CONSULTEE RESPONSE (Council's arboriculturist)

Reference: WA/50/22/PL

Proposal: 1no. 4 bed dwelling with detached garage and associated parking (resubmission following WA/8/22/PL). This application is a Departure from the Development Plan and is in CIL Zone 3 and is CIL Liable as a new dwelling.

Location: Oak Bank, Wandleys Lane, Walberton, BN18 0QR

Site Block Plan 1:200

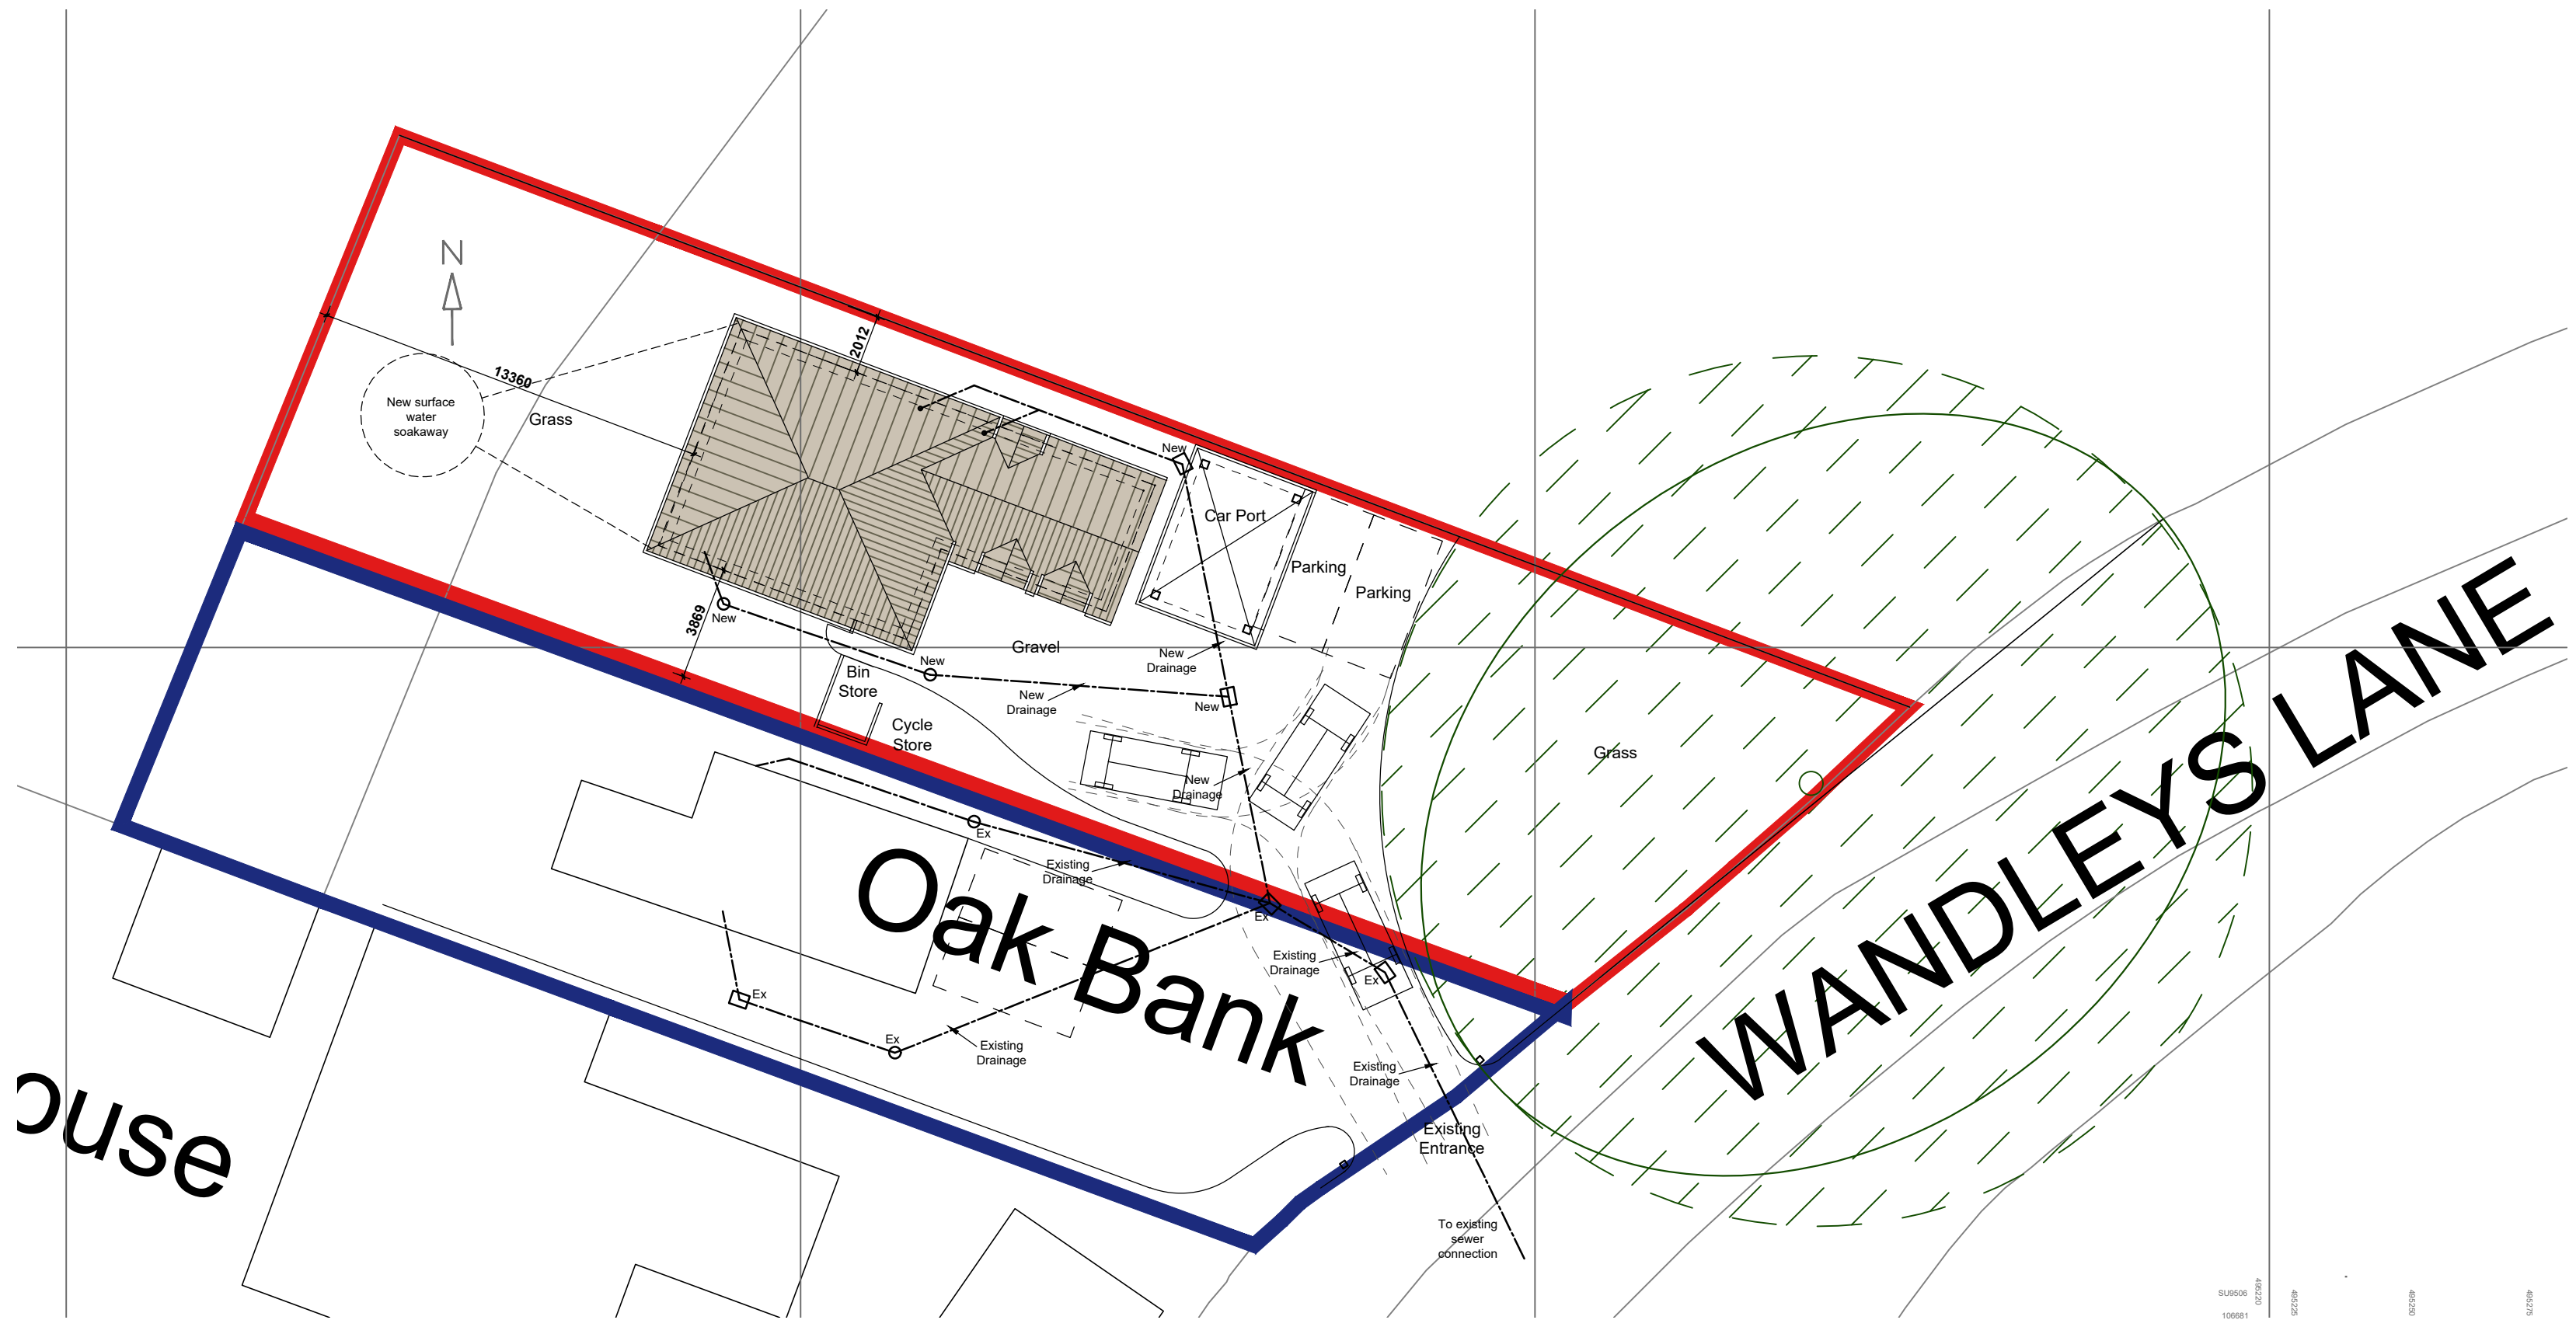
The above report and plan were specific to the preceding application but do not comprehensively associate with the current proposal (block plan) shown on drawing no. 21034/001P Rev F.

T1 is a tree of such importance (high amenity/landscape value, potential heritage tree) and sensitivity (mature, growing in increasingly hostile surroundings) that it should represent a major constraint to development. It is therefore pleasing to see no major construction proposed within the root protection area (RPA) and crown spread, although sensitive working would be required to ensure no overspill into a Construction Exclusion Zone.

There is no approved surface water drainage strategy. As such, if infiltration is not viable then they may need to pursue a connection to the nearby ditch (roadside of T1 oak) involving major work (including excavation) within the RPA.

Foul water and other service-runs in and out of site have not been shown and while it may be straightforward to connect to existing apparatus there remains a risk of further RPA incursion to satisfy those requirements.

The applicant should invite their arboricultural consultant to provide a revised Method Statement and Tree Protection Plan and submit that for our approval.

We should have a surface water drainage strategy (approved by our Drainage Engineer) and detailed plan showing utility routes (Gas, Elec., Foul and Mains water), that do not conflict with RPA of T1, prior to granting consent for this application.
